From: Simon Davis
Sent: 25 January 2019 16:59
To: Planning.Responses
Subject: FW: Y/98/18/RES - Western Boundary & Plot 93-98

In relation to proposed development Y/98/18/RES, I would seek to receive information of the nature of the western boundary with my property in Fairholme Drive.

6xIBF- Affordable.
2 storey
93-98

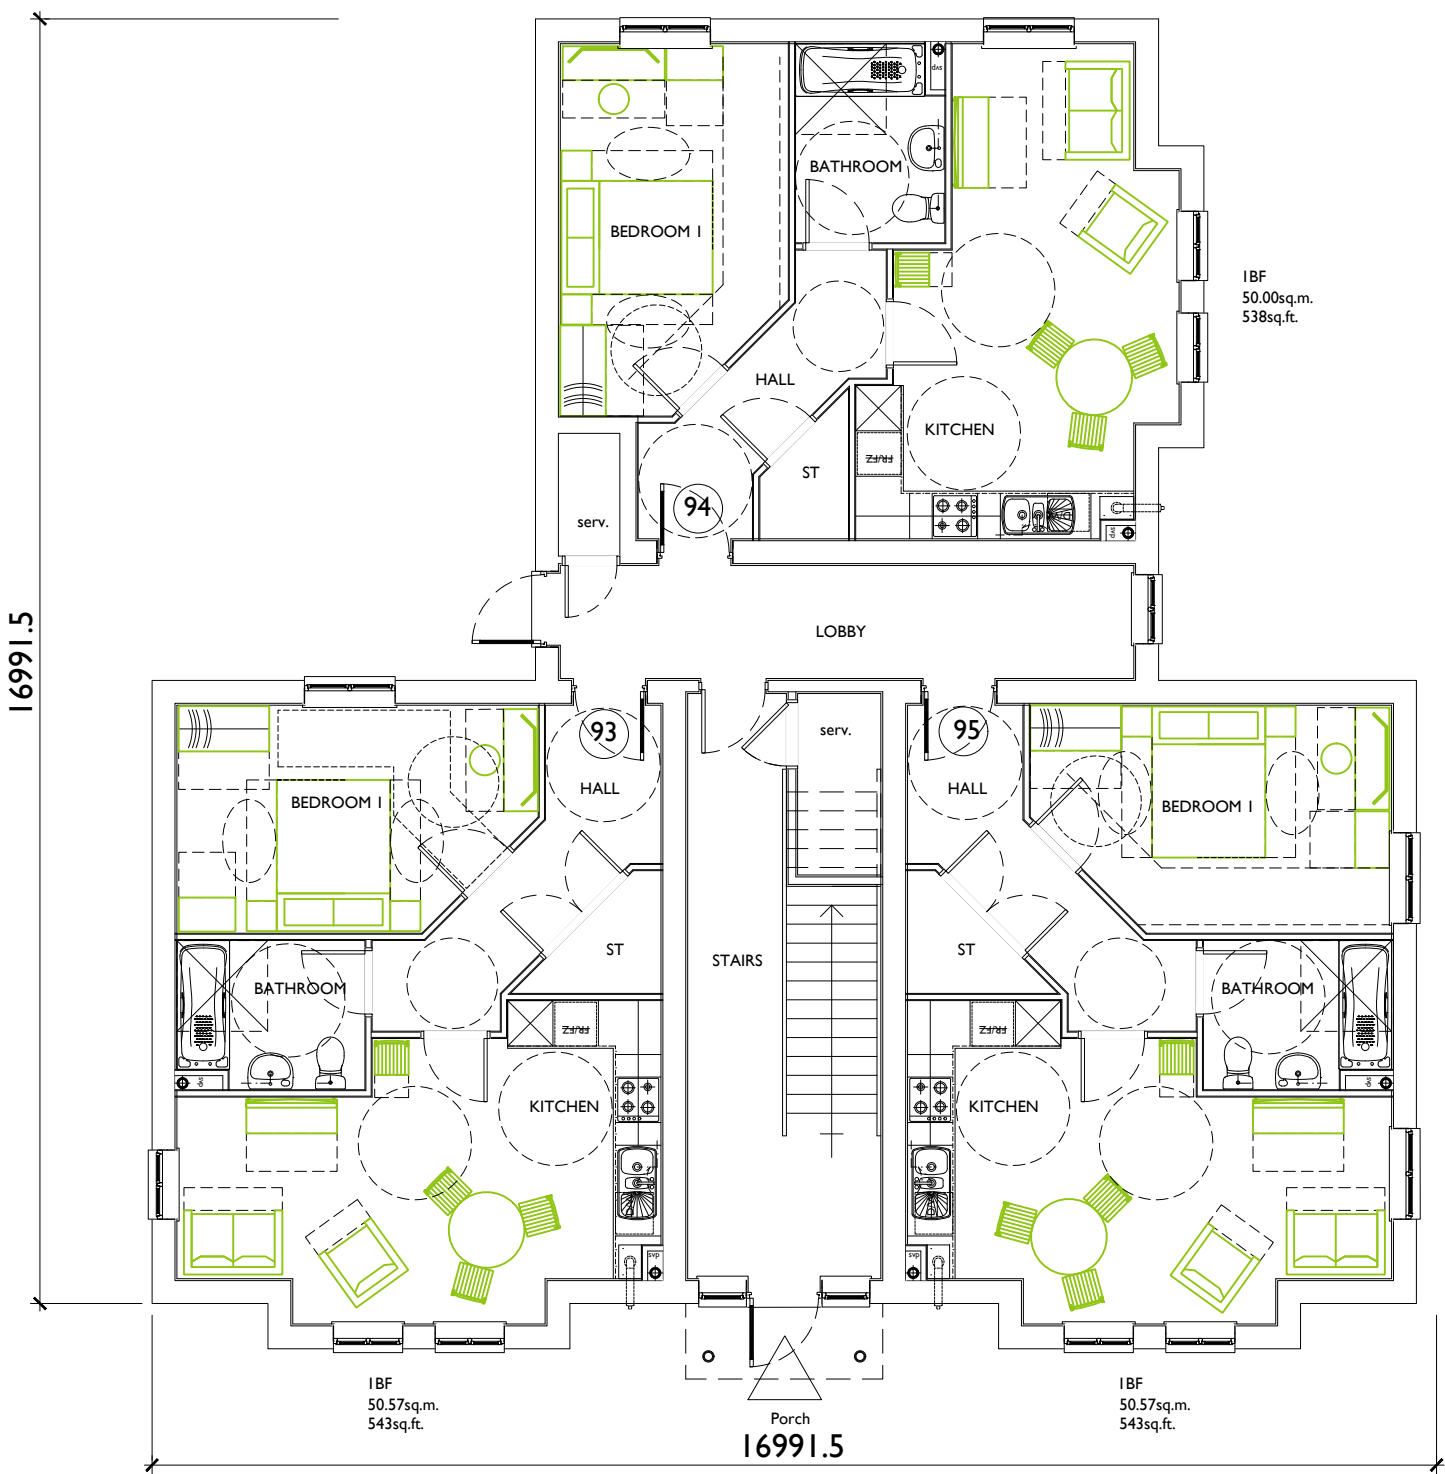
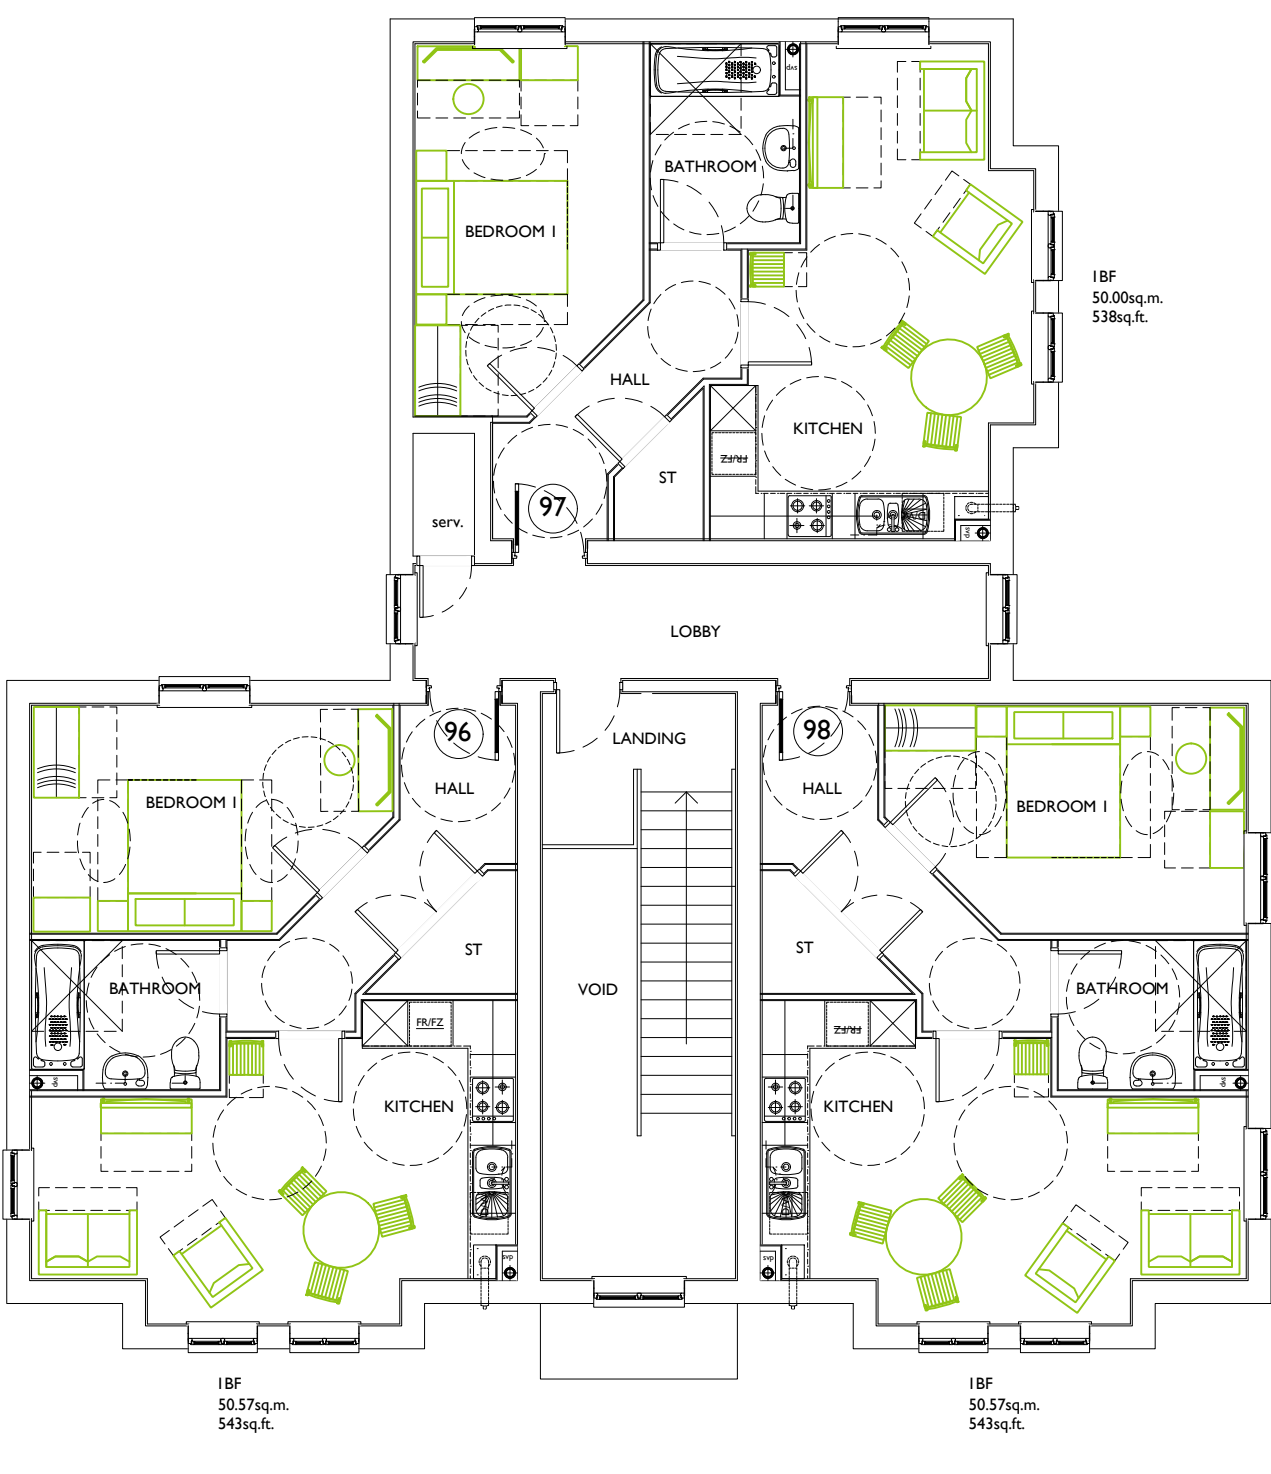
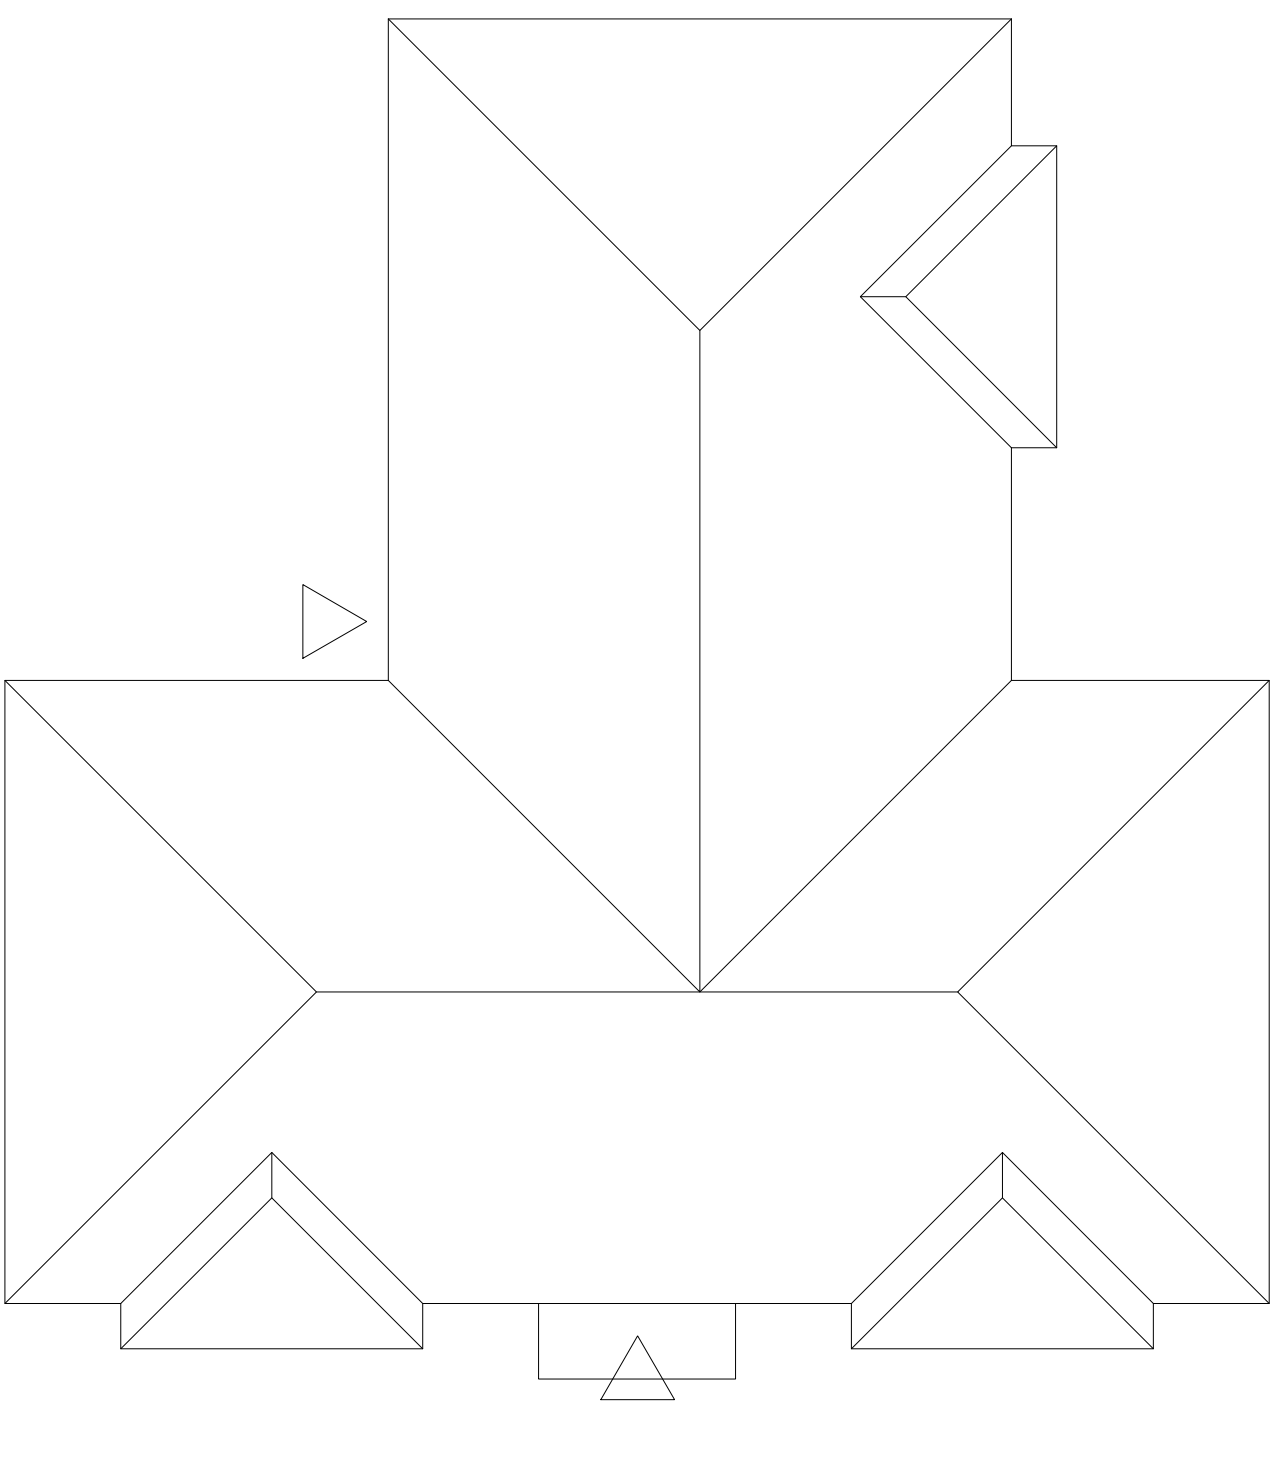
Plot 93 - 98 indicates a dormer window to the western aspect of the proposed building which will subsequently directly overlook my property and afford direct views into my rear bedroom and bathroom windows; clearly this

is unacceptable. On the Site Plan Planning Layout, trees are shown which will reduce intrusion but these are not present on the Soft Landscape Plan.

This was not an issue on the original plans submitted by Gleasons, the previous developer which sited the pumping station in this area. I would like to obtain clarification for the developer and seek assurances that my property will not be directly overlooked; either by means of landscaping measures or relocation of the dormer window. However I believe that acceptable landscaping measures to reduce the overlook would not be possible due to the proximity of overhead power lines.

It does look on the roof plan as though there is to be a dormer looking towards your property. However, if you look at the elevation drawing, you will see that the building is only two storeys with a roof gable feature above. I have also measured the distance between your house and the new wall and it will be 23-25m (depending on the part of the new building measured to). We would normally look for a minimum of 20m between two storey properties. Please advise if you would like to add your comments to the file as a representation.
